23 August 2018

Re: Response to Agency (Ku-ring-gai Council and OEH) comments – Lindfield Learning Village (SSD 8114).

This letter has been prepared in response to the comments made by Ku-ring-gai Council (Letter to Teresa Gizzi dated 17 July 2018) and the Office of Environment and Heritage (OEH) (Letter to Karen Harragon dated 19 July 2018) to a Biodiversity Assessment Report (BAR) prepared by Ecoplanning for the above development (report dated 1 June 2018). A response is provided for each of the comments below (**Table 1**).

Figure 4.1: Targeted survey effort.

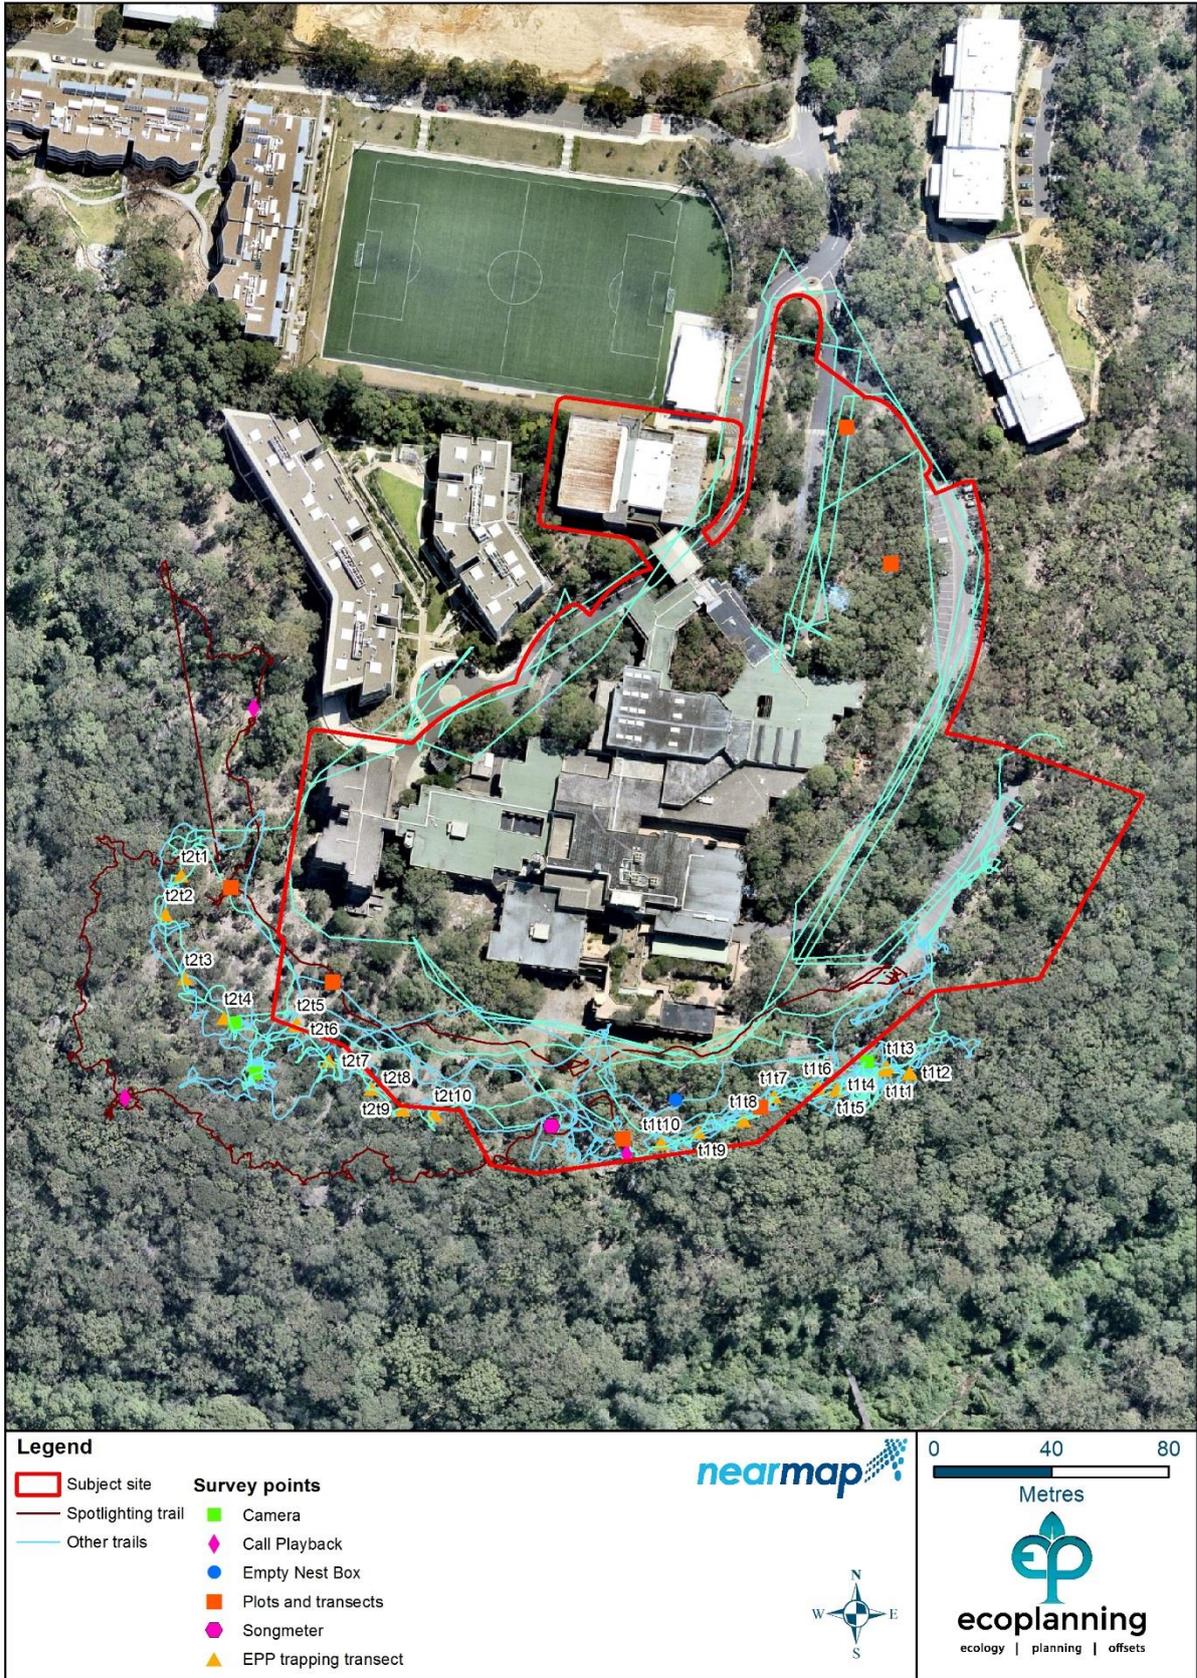
Ku-ring-gai Council Comments	
Comment	Response
<p>The Biodiversity Assessment Report (BAR) prepared by eco-planning consultants assumes the absence of threatened fauna (species) as none were detected within the development area at the time of the fauna surveys.</p> <p>A detailed flora and fauna investigation was undertaken ERM Australia over the former University Technology, Sydney (UTS) site as part of the part 3a concept plan approval (Application Number: 06_0130).</p> <p>ERM Australia whom prepared the flora and fauna assessment recorded the following threatened species: <i>Darwinia biflora</i>, Red-crowned Toadlet and Powerful Owl within the UTS site.</p> <p>The habitat/vegetation to be removed as a result of the proposed development and the asset protection zones provides known habitat for these species. The BAR fails to provide any species credits to offset the loss of habitat as a result of the proposal. An amended BAR should provide species credits to offset the loss of known habitat for <i>Darwinia biflora</i>, Red-crowned Toadlet and</p>	<p><i>Darwinia biflora</i> is not considered a species credit species as it is not a candidate species for either of the two PCTs identified within the subject site. Given that ERM (2004) recorded the species close to the current subject site Ecoplanning conducted numerous targeted flora surveys across the subject site (Figure 1):</p> <ul style="list-style-type: none"> • 24/03/17 - 7 hours, Lucas McKinnon • 27/03/2017 - 6 hours, Tom Hickman • 5/05/2017 - 17 hours, Tom Hickman and Tammy Paartalu • 23/11/2017 - 2.5 hours, Tammy Paartalu <p>Ecoplanning botanists (Tammy Paartalu and Tom Hickman) identified and counted a number of <i>Darwinia biflora</i> outside of the subject site to the east of Charles Bean oval but no individuals were recorded within the subject site.</p> <p><u>Red-crowned Toadlet</u> Survey effort for the species is specified in Table 4.3 of the BAR and included call playback</p>

Powerful Owl.	<p>conducted over two survey nights on 27/03/2017 and 12/04/2017. Daylight survey was conducted in all areas of potential habitat, including intermittent drainage lines with a build-up of litter or other debris. The location of call playback was outside of the subject land to the west, prior to knowing the current extent of the direct footprint, but within the APZ (Outer Protection Area).</p> <p>Additional survey is not considered necessary.</p> <p><u>Powerful Owl</u> is not considered a Species credit species following assessment of geographic and habitat features in the credit calculator. Essentially this means there are no hollow bearing trees to constitute suitable breeding habitat within the subject site. The subject site represents foraging habitat only. Powerful Owl is, is considered an Ecosystem credit species for foraging habitat and has been treated as such in the BAR.</p>
